DECISION DELEGATED TO HEAD OF PLANNING

Application No: H09-1079-24 **Applicant:** A Sukerno
Proposal: Proposed residential development - 9 dwellings
Location: Hooks Of Holbeach Land Adj & Including 45 Fleet Street Holbeach
Terminal Date: 28th February 2025

Drawing  
 PLOTS 9  
 FLOOR PLANS - PROPOSED  
 ELEVATIONS - PROPOSED

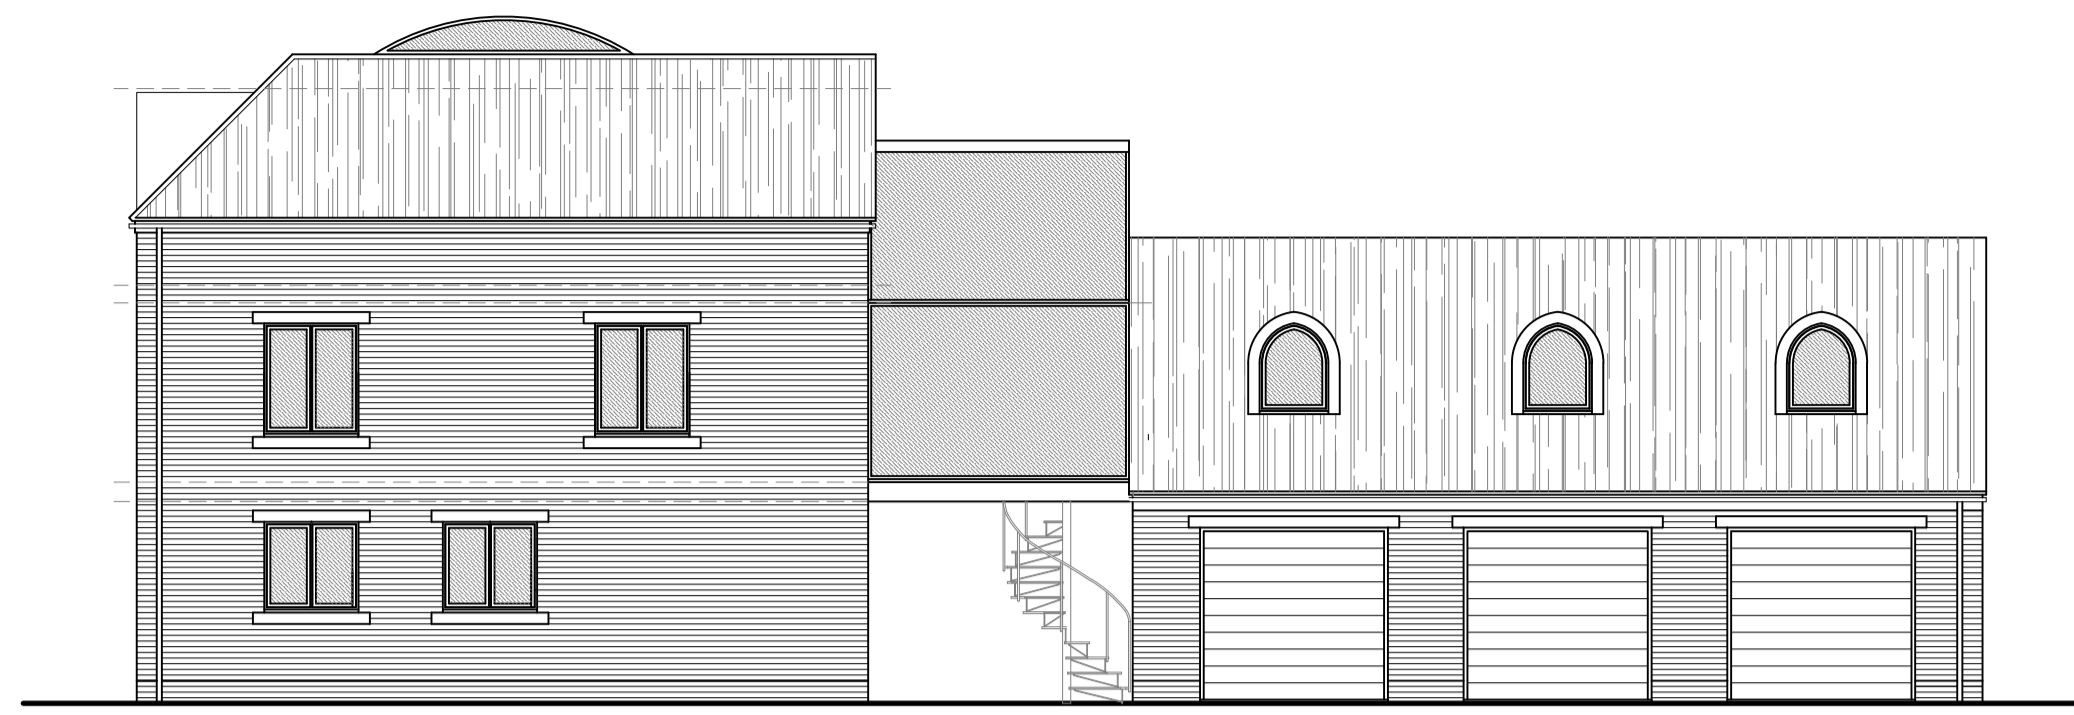
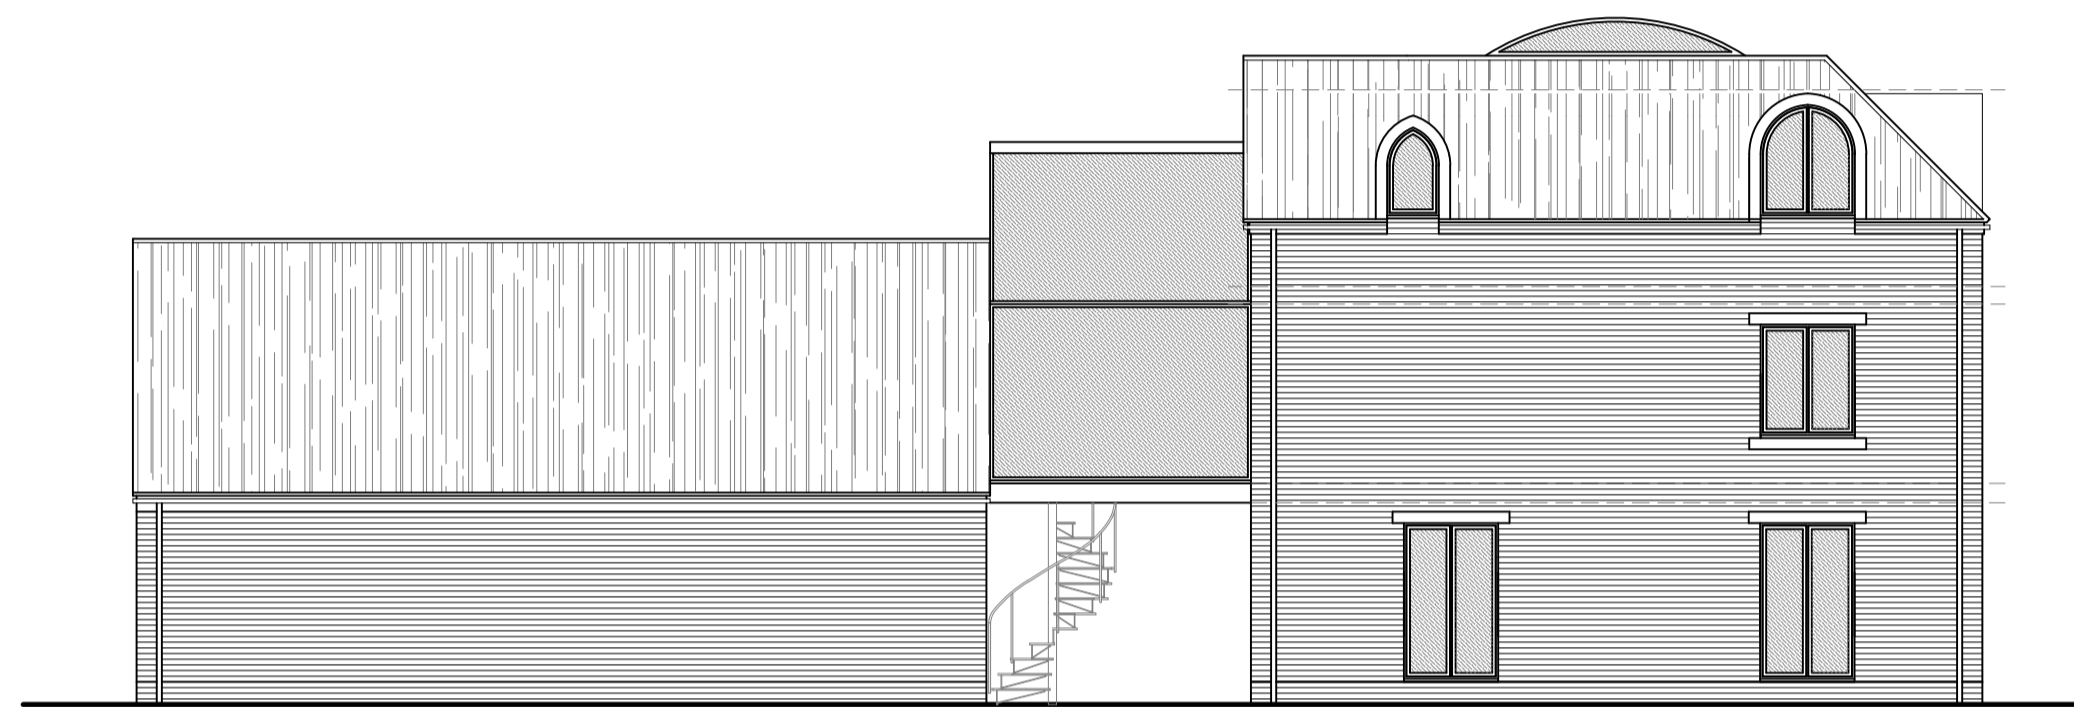
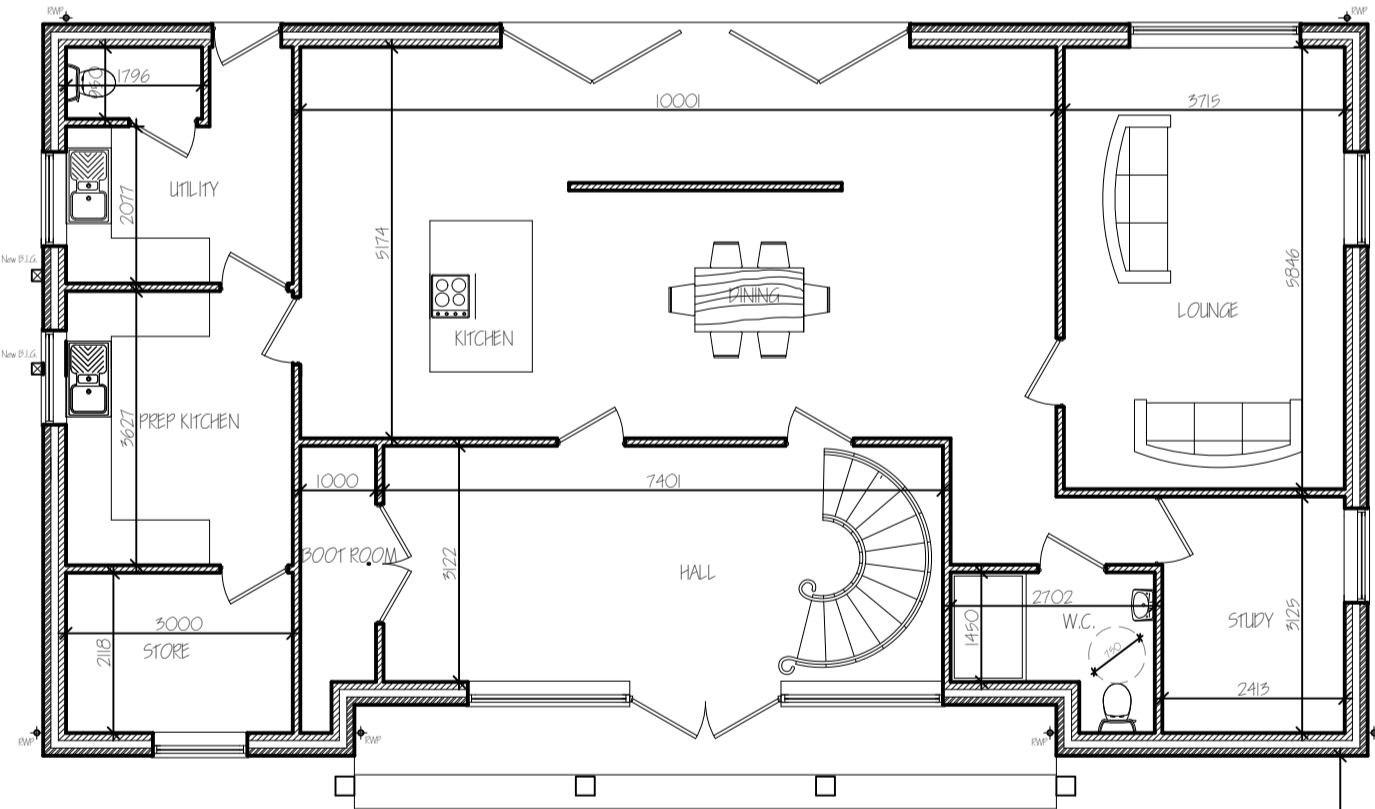
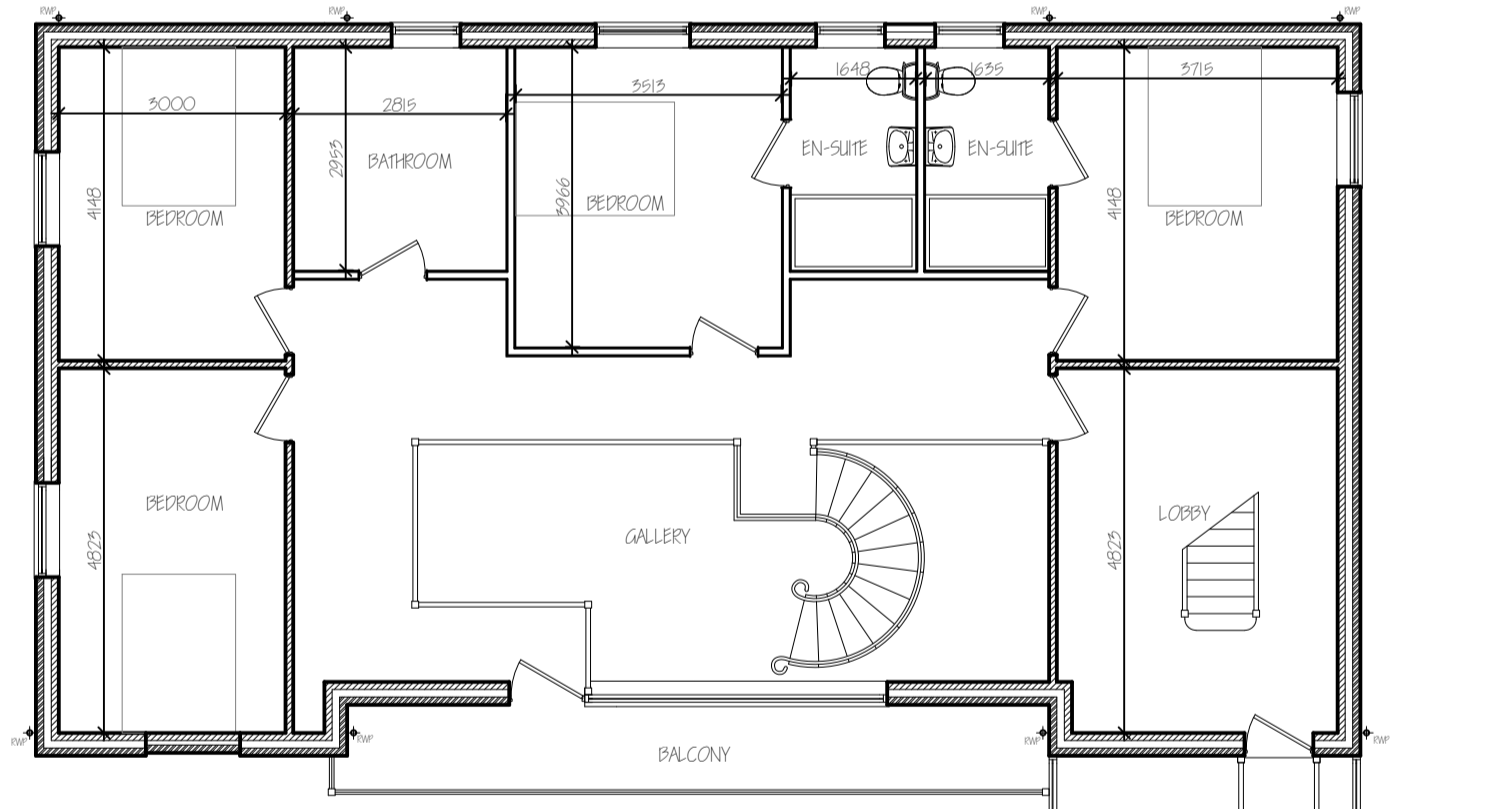
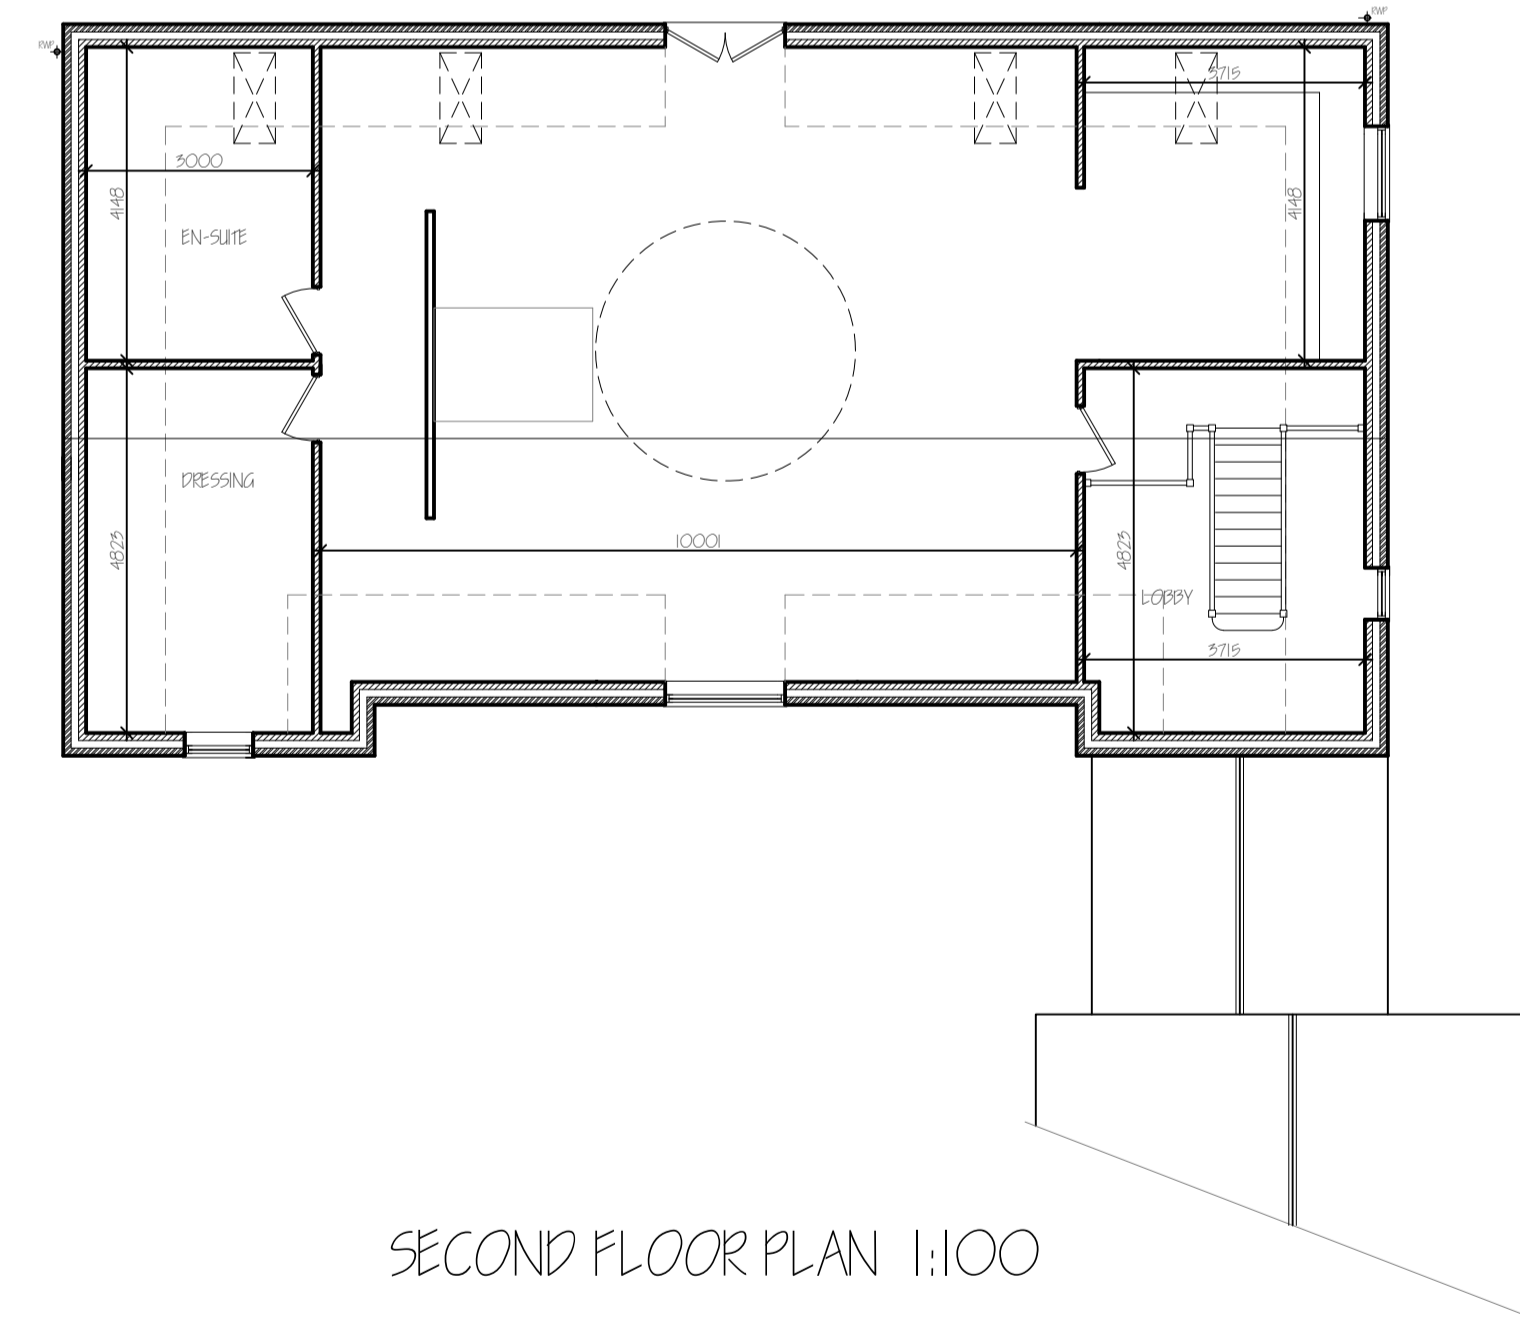
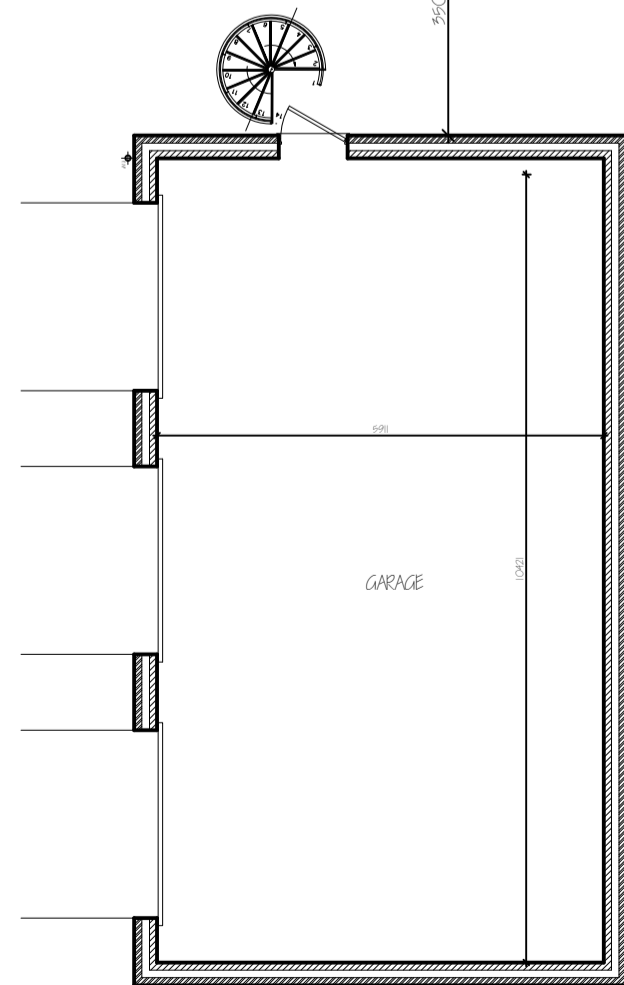
The proposed development of Plot 9 would comprise a large, detached dwelling accessed off Fleet Street. The location of the dwelling would be set back from the rest of the development, that has a road frontage. The proposed dwelling would measure approximately 17.4m by 9.6m with a two storey front projection of 14.5m, with a maximum height of 9.03m. There are no examples of residential dwellings of this size within the area. The design of the dwelling includes heavy glazing to the front elevation of the dwelling, with a two storey front projection being of a front link design, there are no examples of heavy glazing within the area.

The dwelling is of an extensive scale and comprises a convoluted and contrived design, which is out of keeping with that of the surrounding context of residential dwellinghouses. In addition, due to the siting of the triple garage associated with Plot 9, which is two-storey in scale, being located forward of the principal elevation, this form creates an additional unacceptable and harmful impact upon the street scene of Fleet Street.

Map 2: Habitat map for land off Fleet Street, Holbeach.

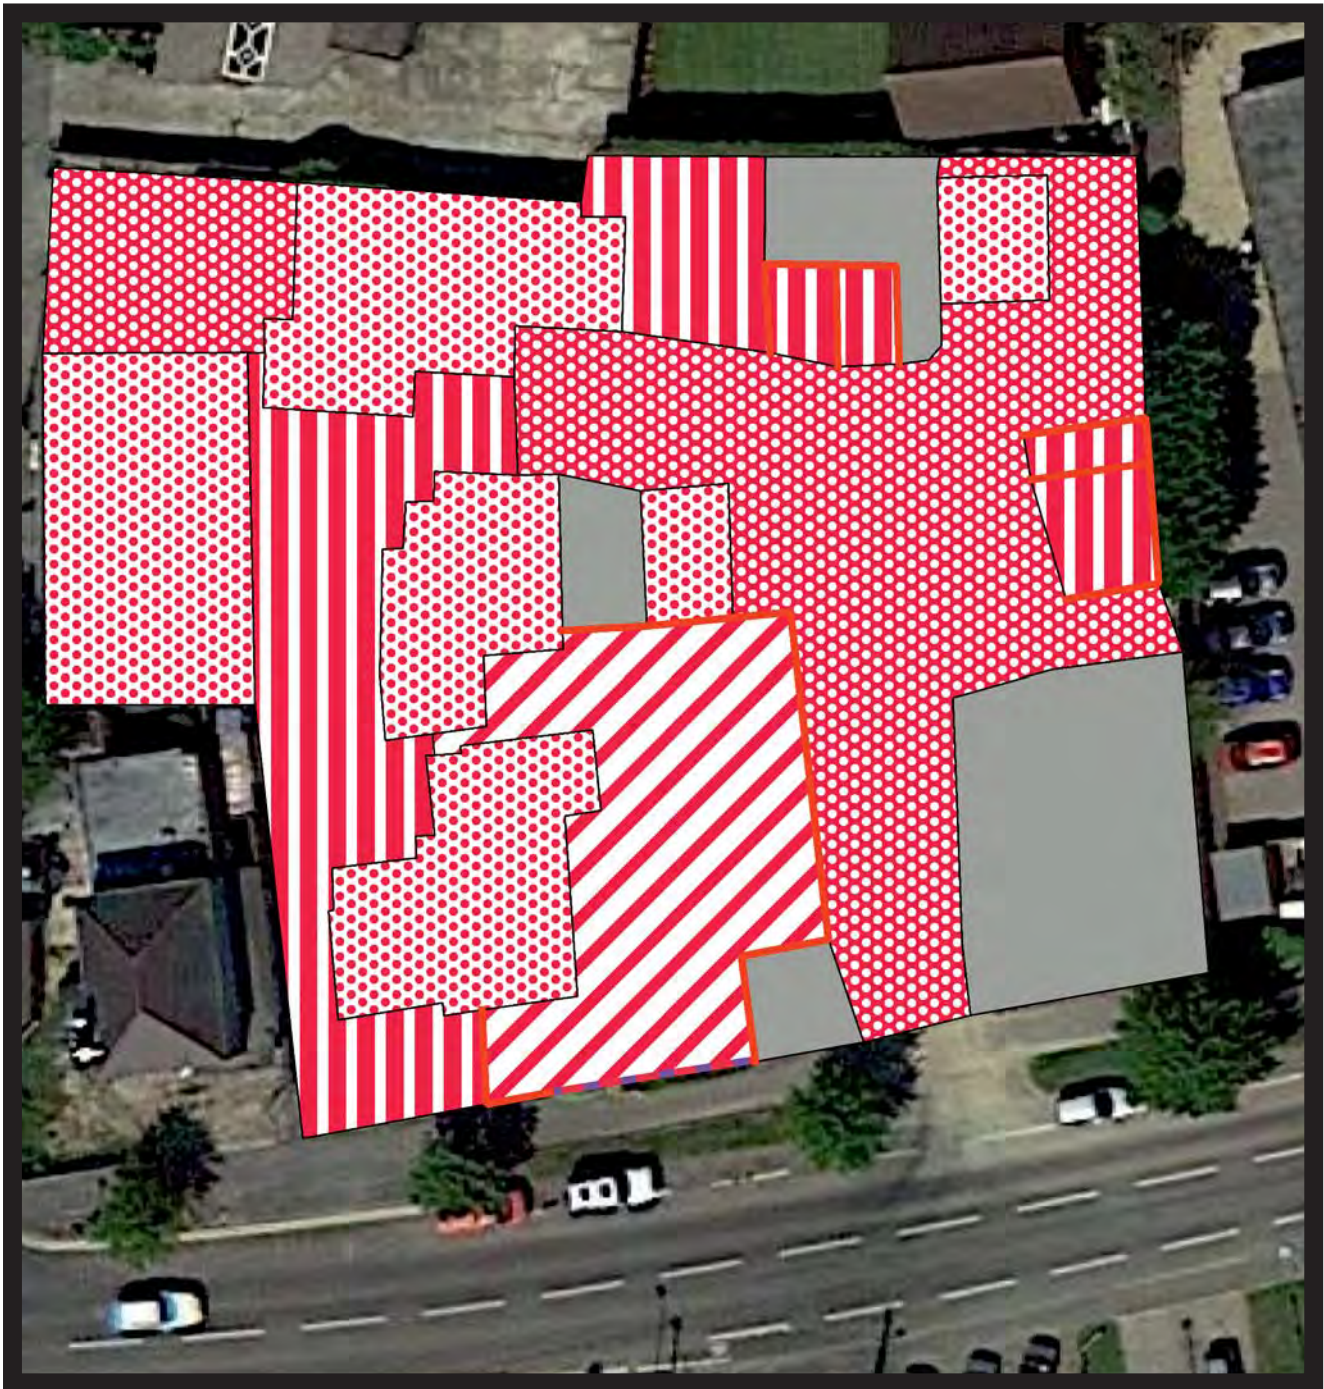
Yes, I've reviewed the PEA/BNG assessment and metric, and find that there are issues with the BNG assessment related to the lack of labels in the baseline habitat map and the lack of an interpretable post-development habitat map, which make it difficult to interpret the information within the metric. However, despite these problems, I would judge that the authority can be reasonably confident that the proposal can achieve the 10% mandatory BNG requirement due to the relative ecological simplicity of the site.
